From: Laura Gibbons
Sent: 07 August 2018 12:42
To: Planning.Responses
Subject: RE: Planning Consultation on: BN/39/18/HH

Engineers Comments Regarding Drainage

APPLICATION **BN/39/18/HH**

Description of Works: Replacement front porch

PLAN AND ELEVATIONS OF PROPOSED PORCH

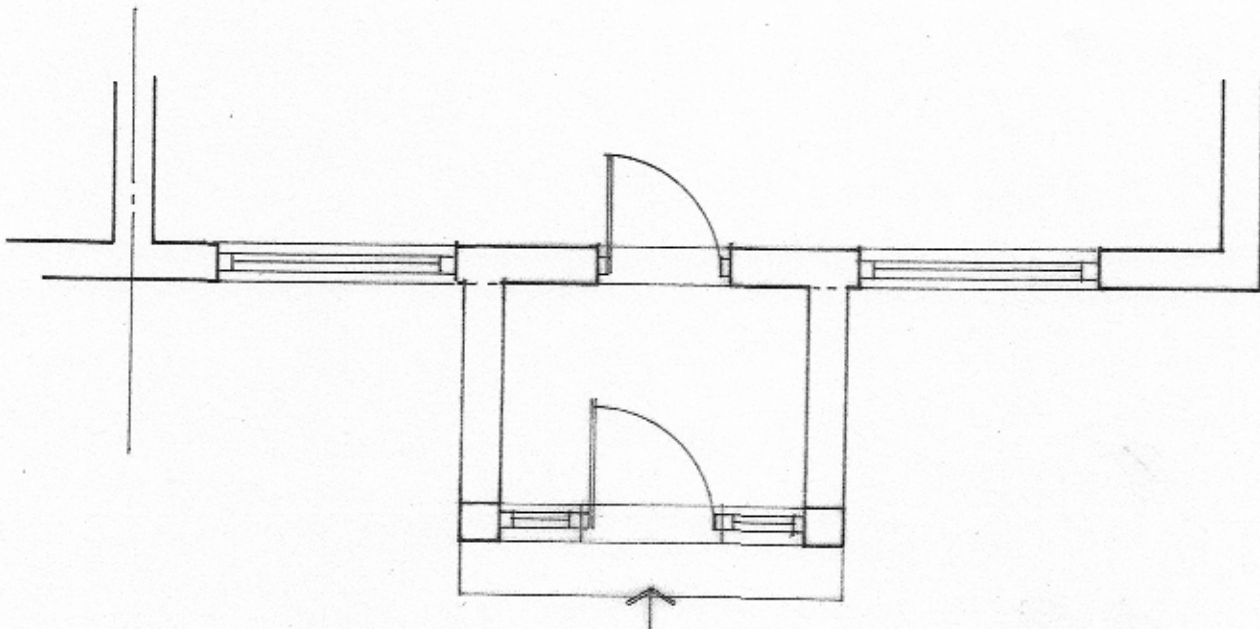
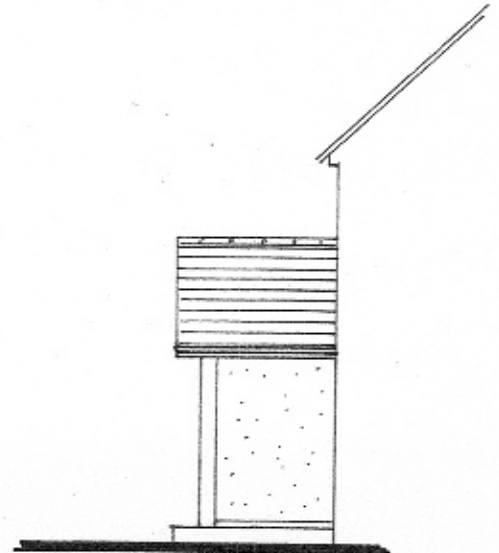
The roof water should not be disposed of into the sewer. Infiltration should be used. Please see our attached further guidance notes for more details.
